City of Albuquerque
Building Safety Project Comments
600 Second NW
Albuquerque, NM 87102

Re: Playhouse Learning Center
809 Old Coors Dr. SW
Architect Stamp Date: 2/3/2021 (L11D069)

SHEET NUMBER
FIRE 1.0

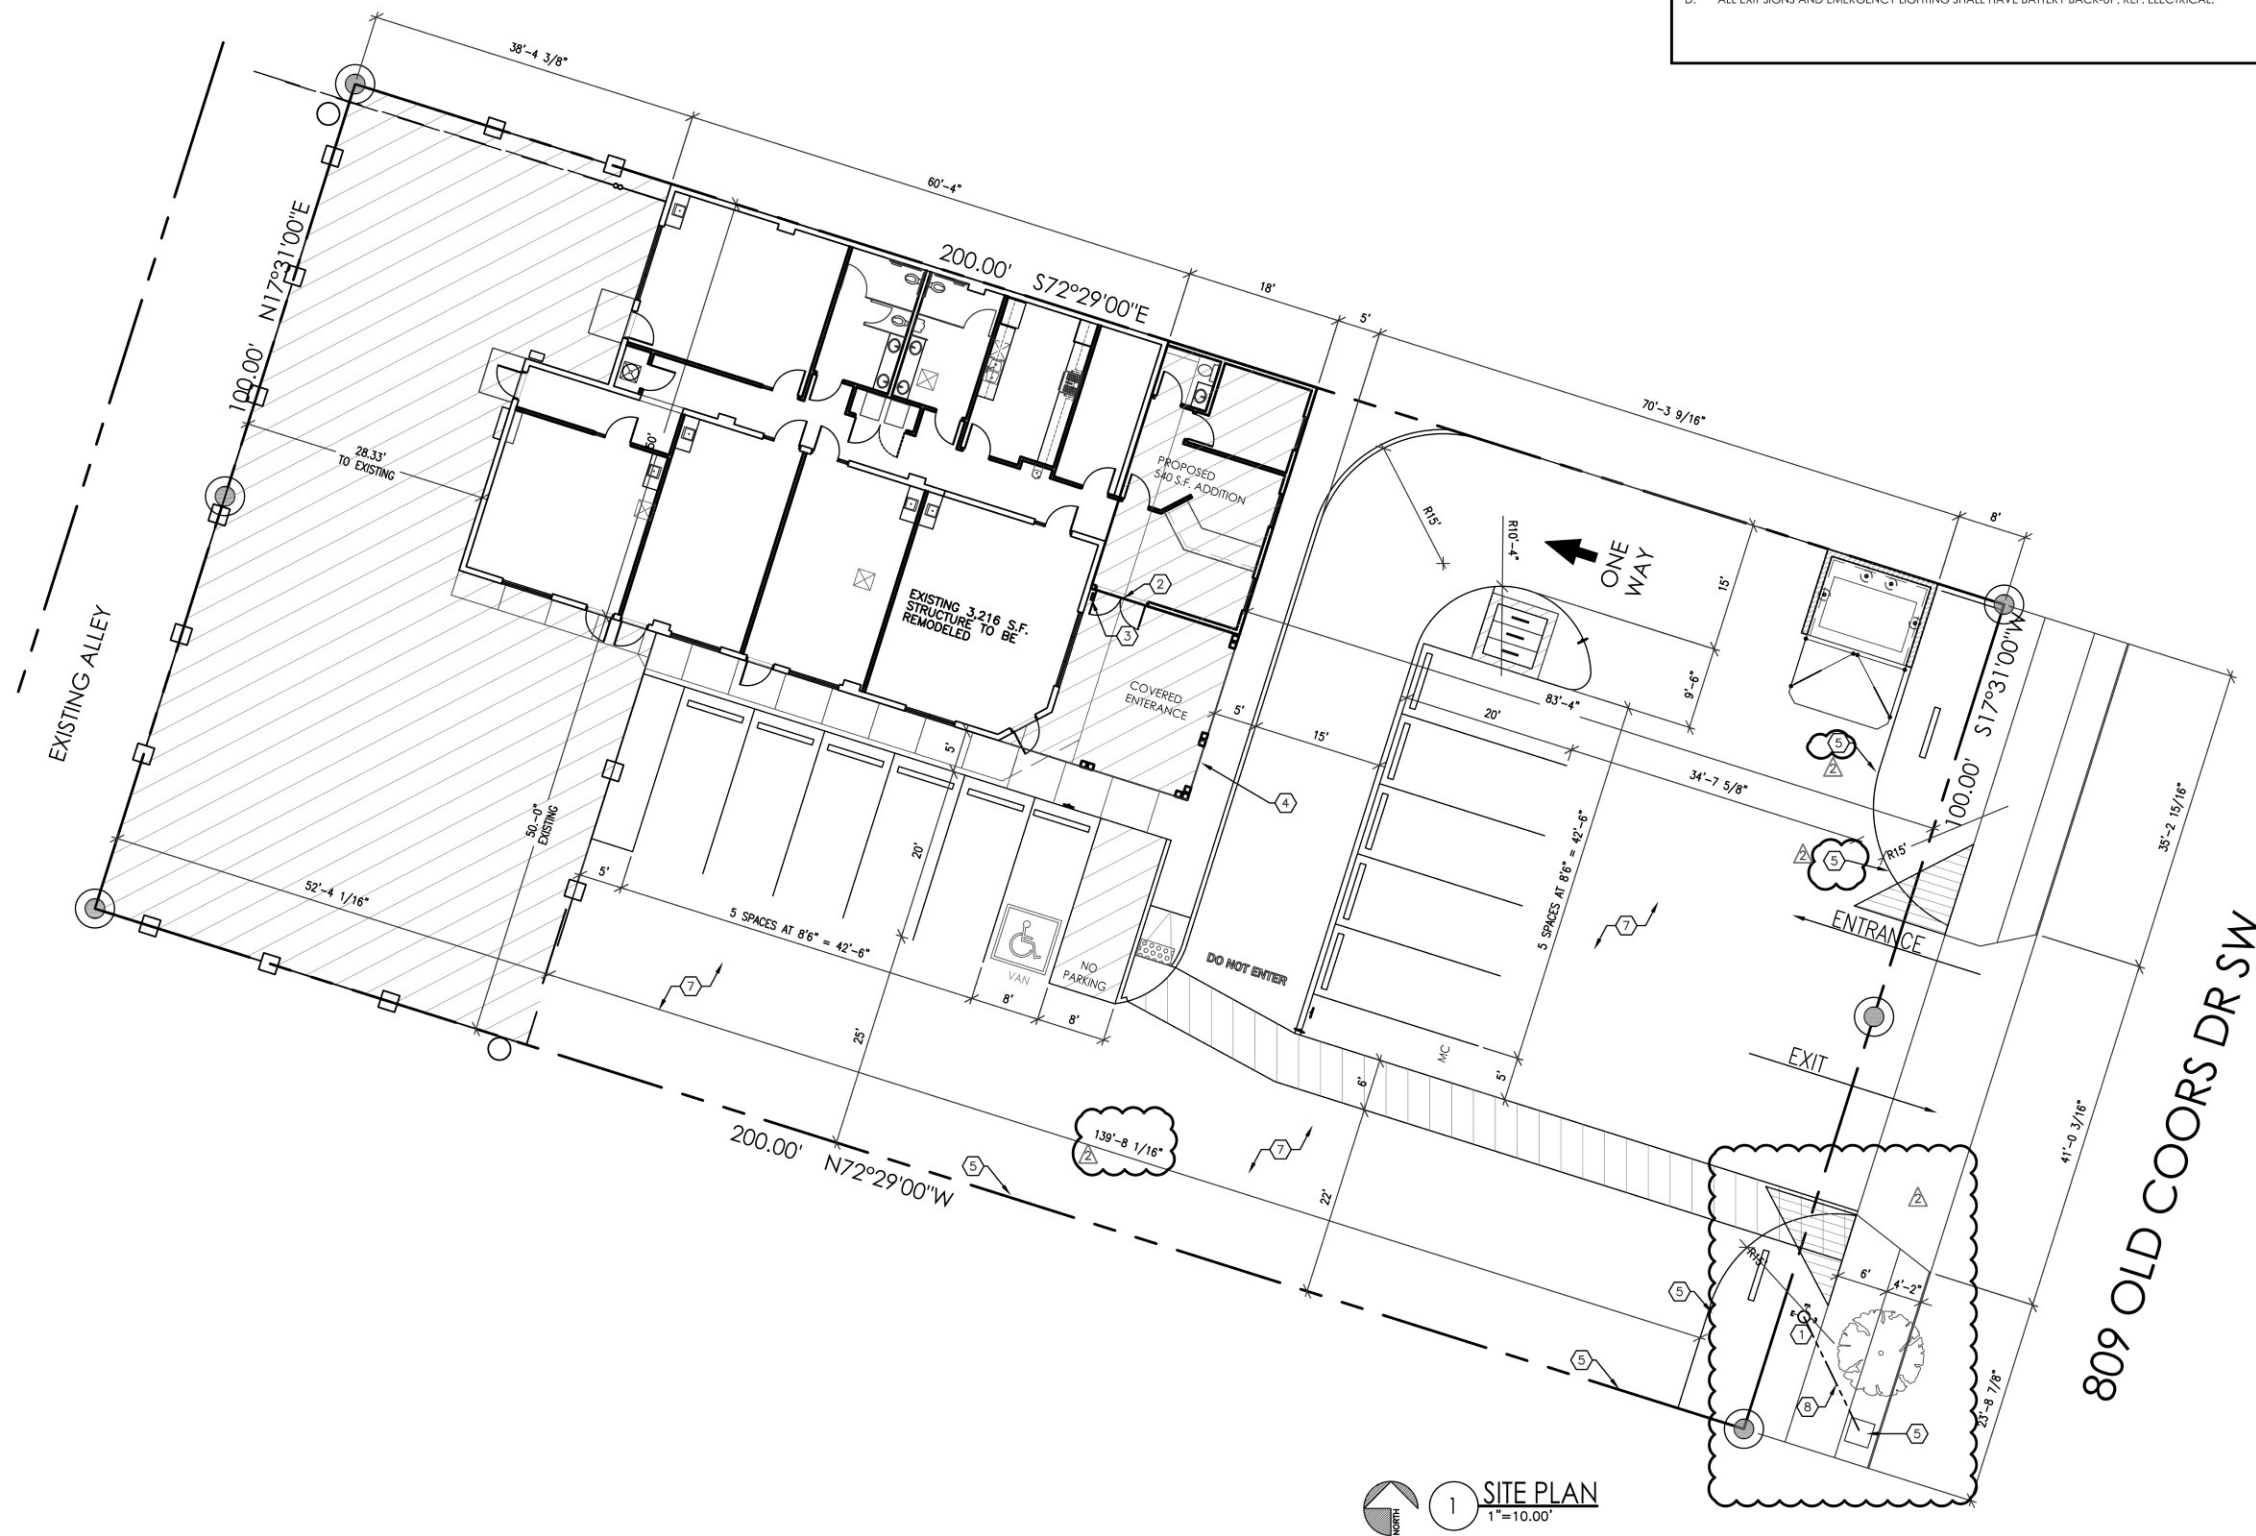
8. Fire and emergency access: Provision for access by fire and emergency vehicles needs to be in accordance with the Albuquerque Fire Plan Checking Division. Provide approval from the Fire Marshall. **Please see attached approved Fire 1.0 plan**
